16 August 2021

NL191366.B14

Re: John Hunter Health and Innovation Precinct – Civil Updates following SSDA Submission

JOB NUMBER <b>NL191366</b>	DRAWING NUMBER <b>C401-DA</b>	REVISION <b>7</b>
DRAWING SHEET SIZE = A1

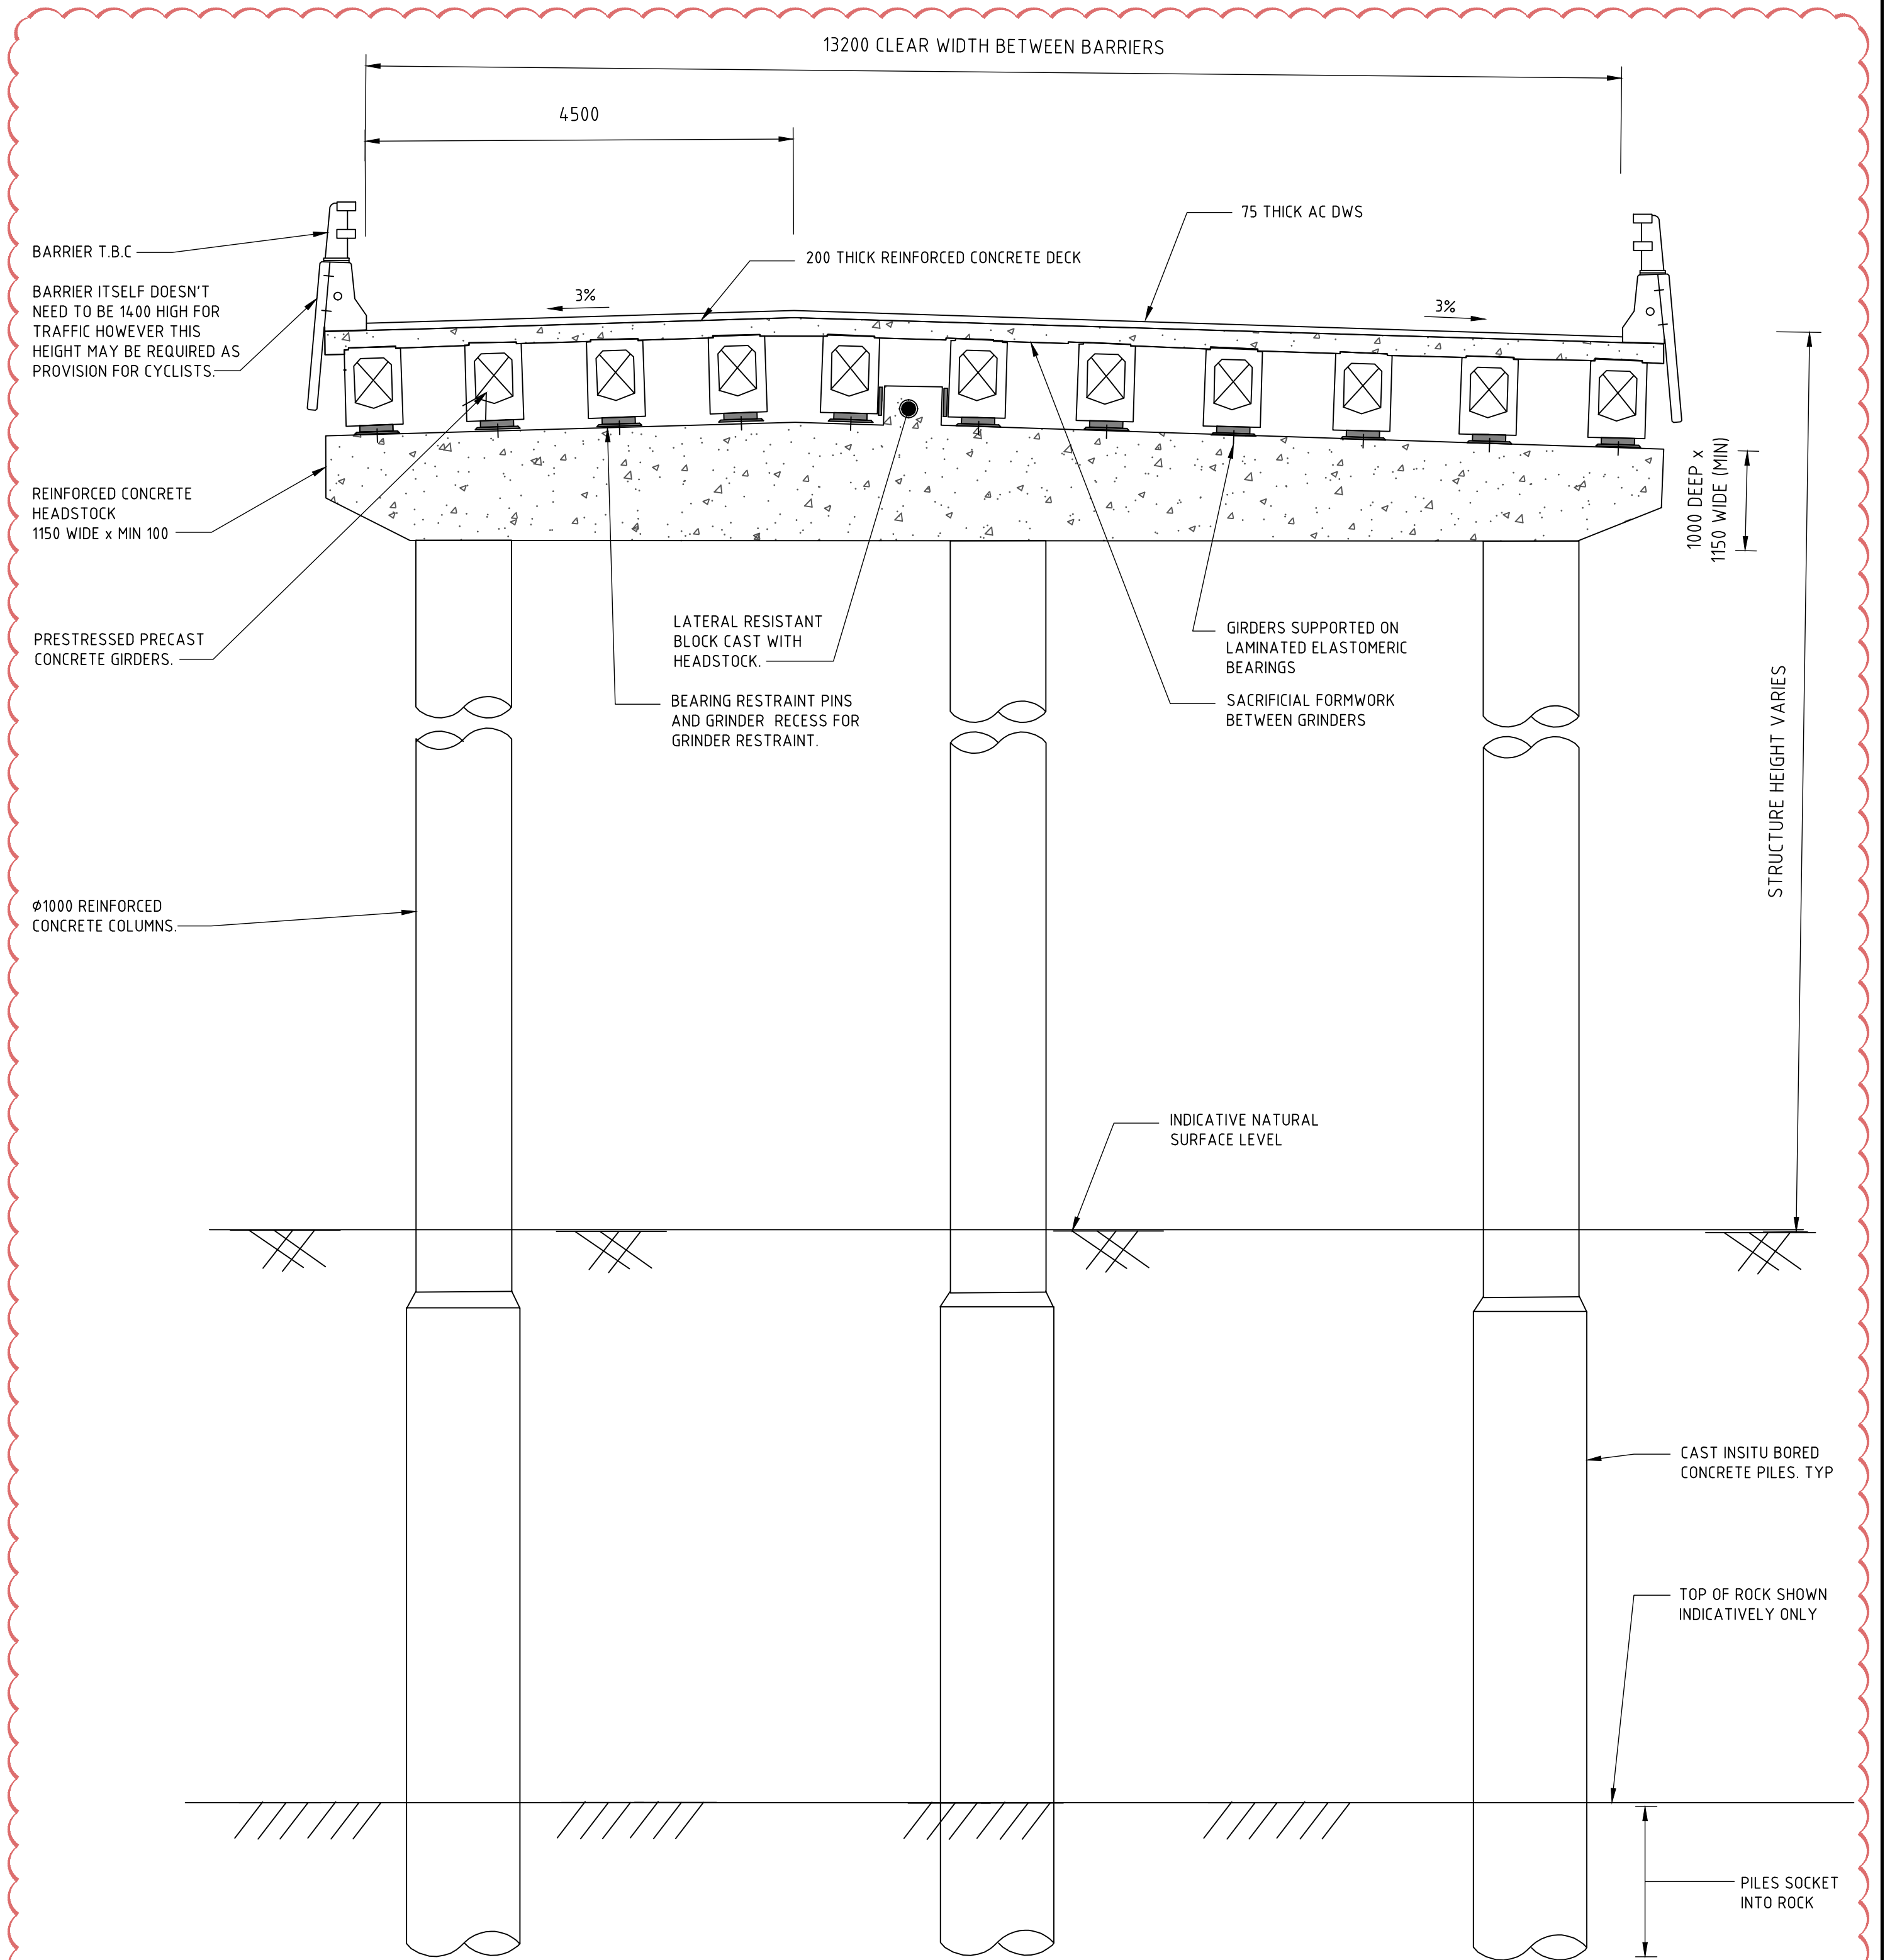
- Inclusion of a bridge along the western link road to reduce filling and retaining wall extents. The concept bridge cross section is noted on drawing C401-DA and can be summarised as:
 - Precast concrete plank deck with Asphalt overlay
 - Reinforced concrete substructure
 - Bridge extents to be 100m long x 14m wide.
 - 1.2m high bridge code compliant barriers to be provided both sides.
 - Scuppers to be provided for drainage in lieu of previously nominated in ground stormwater.
 - No façade provision, bridge will be concrete finished with the exception of barrier as appropriate.
